RE: Application for – 35 Providence Street
(ID# 2003-0232, CBL#169-A-035)

Thank you for your application for your single family at 35 Providence Street. Upon review, planning has the following comments:

TO: Inspections Department
FROM: Jay Reynolds, Development Review Coordinator
DATE: April 22, 2004
RE: C. of O. for #33 Providence Street
(CBL 169A035) (ID 2003-0232)

PLAN SHOWING A STANDARD BOUNDARY SURVEY MADE FOR
MARK FLOURDE
 PORTLAND, MAINE

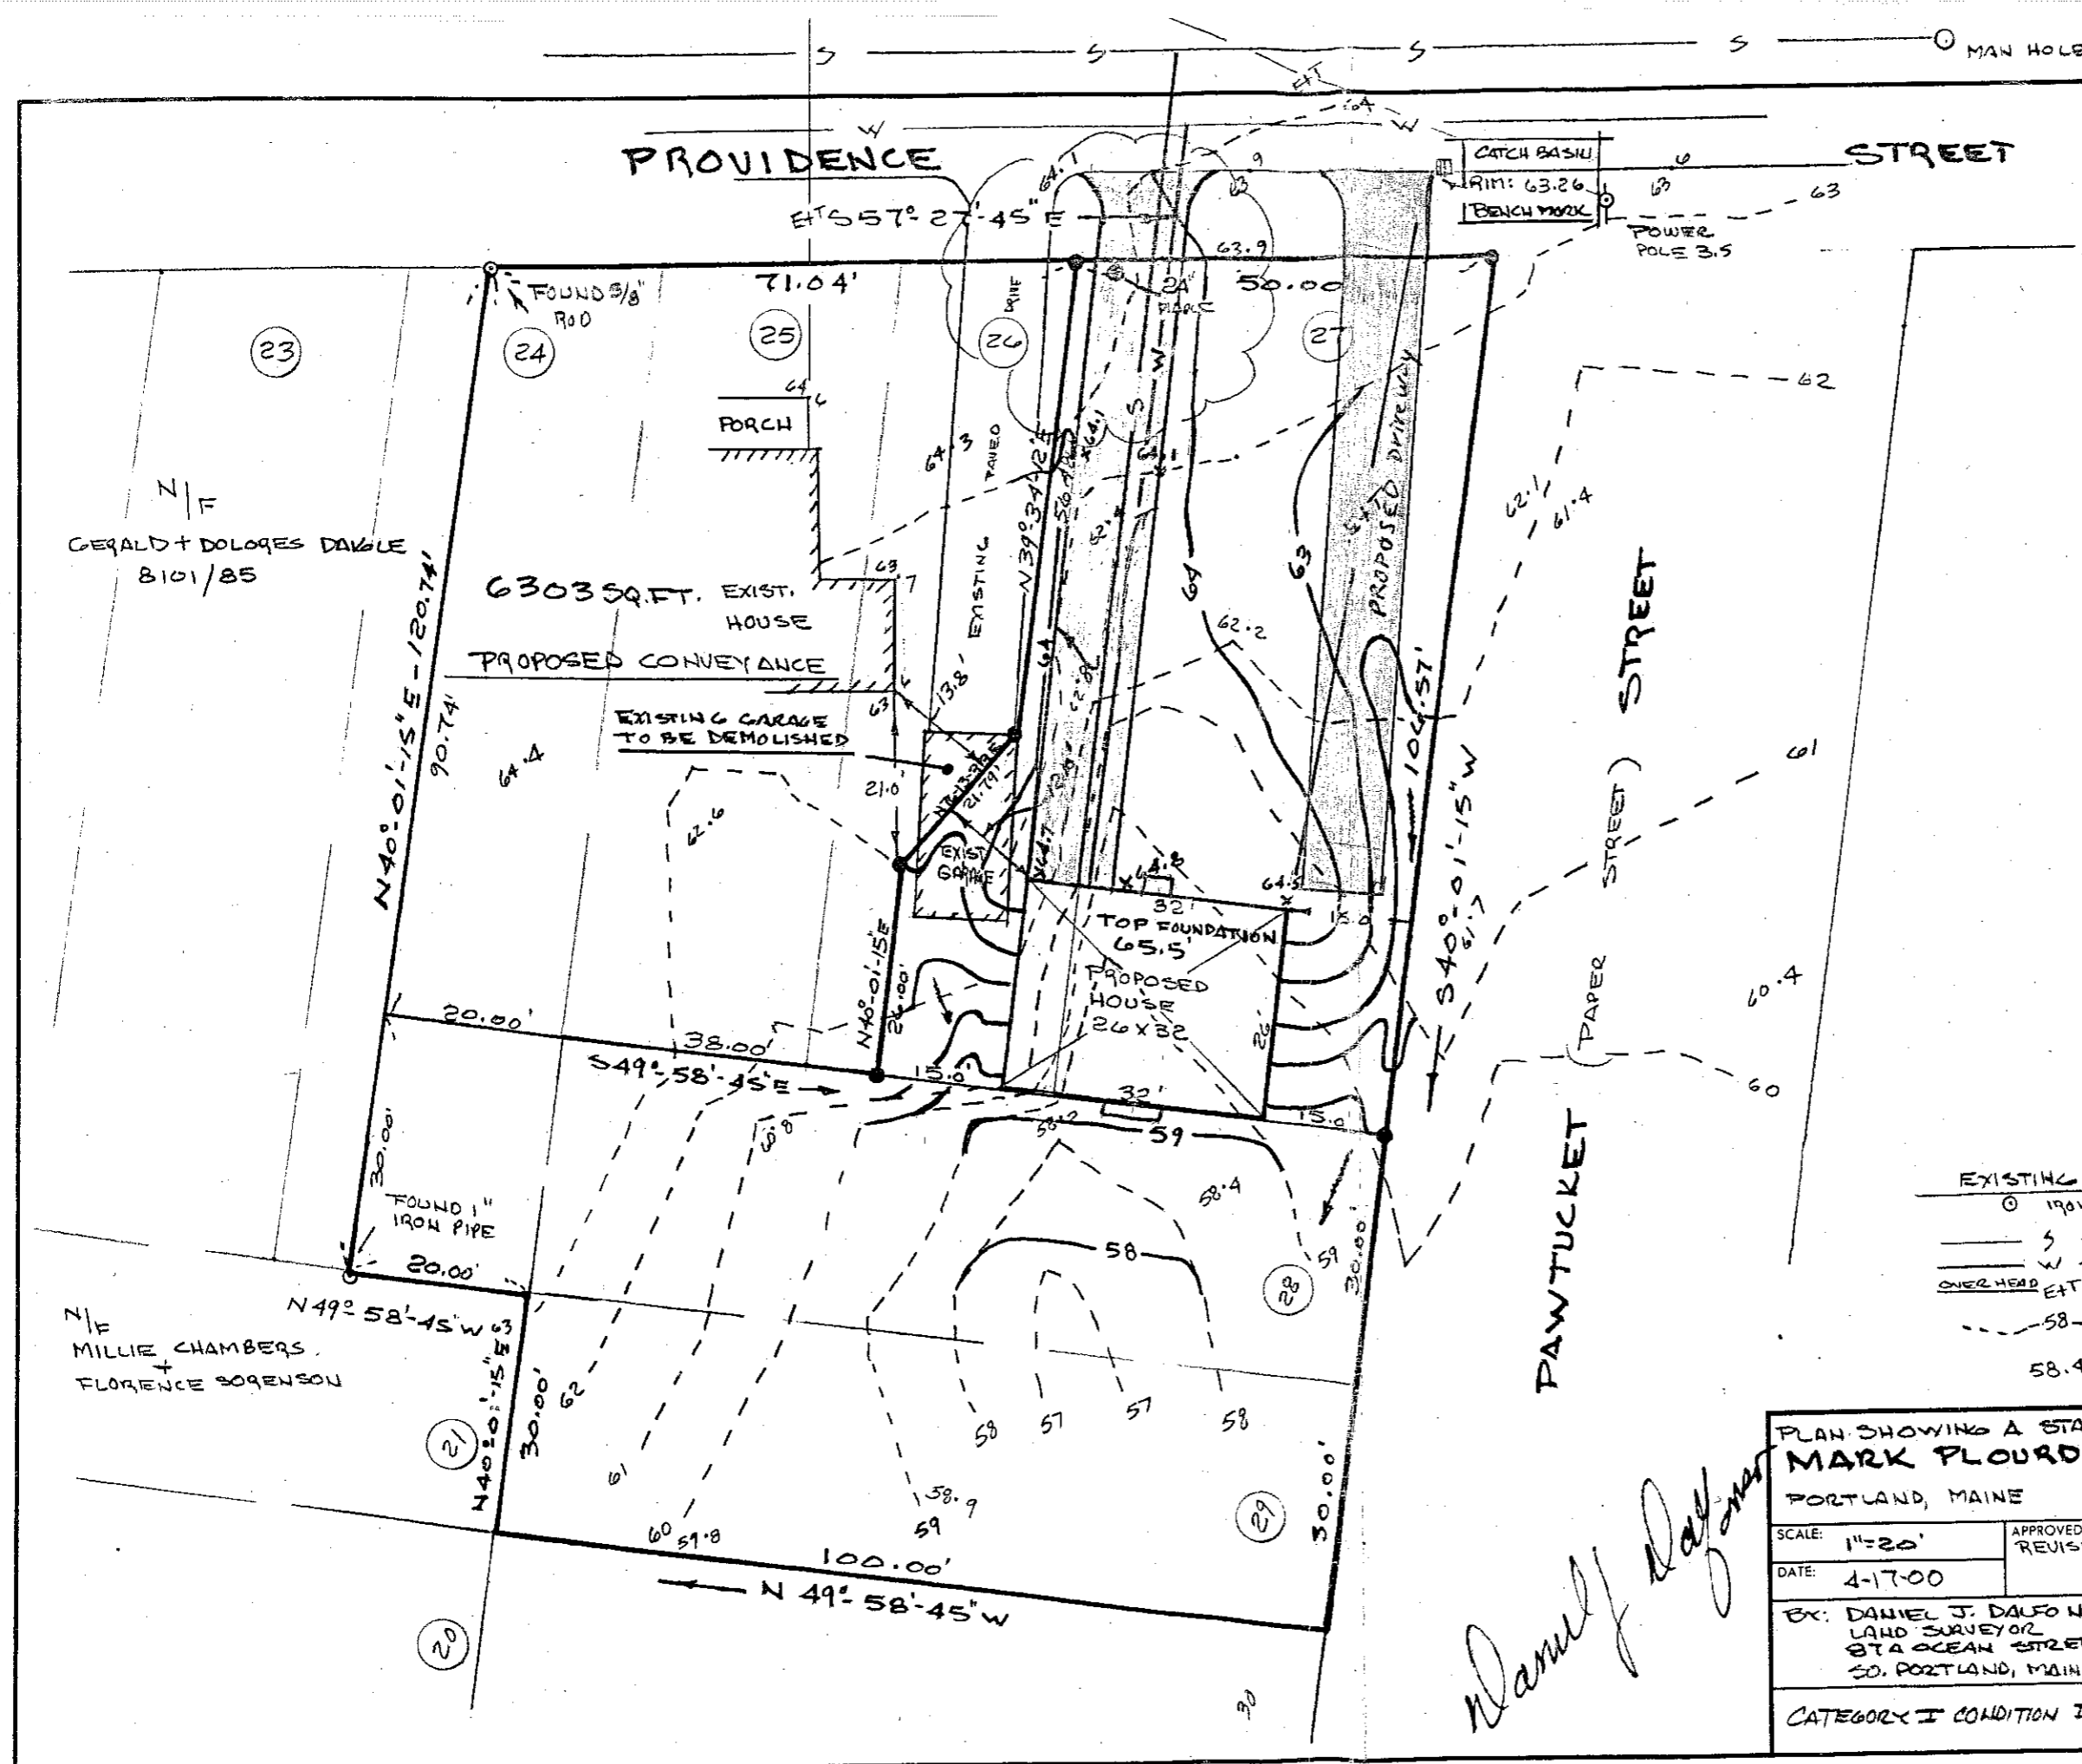
1. Please add a cleanout to the sanitary sewer lead. *Cleanout*
2. Please add two street trees to your site plan, as required for single family development. *Good*
3. The site plan appears to show two driveways/curb cuts. Is this correct? *One Curb Cut*

- 1 A CLEANOUT WILL BE REQUIRED ON THE SEWER LEAD.
- 2 All damage to sidewalk, curb, street, or public utilities shall be repaired to City of Portland standards prior to issuance of a Certificate of Occupancy.

- 3 Two (2) City of Portland approved species and size trees must be planted on your street frontage prior to issuance of a Certificate of Occupancy.
- 4 Your new street address is now #33 Providence Avenue, the number must be displayed on the street frontage of your house prior to issuance of a Certificate of Occupancy.
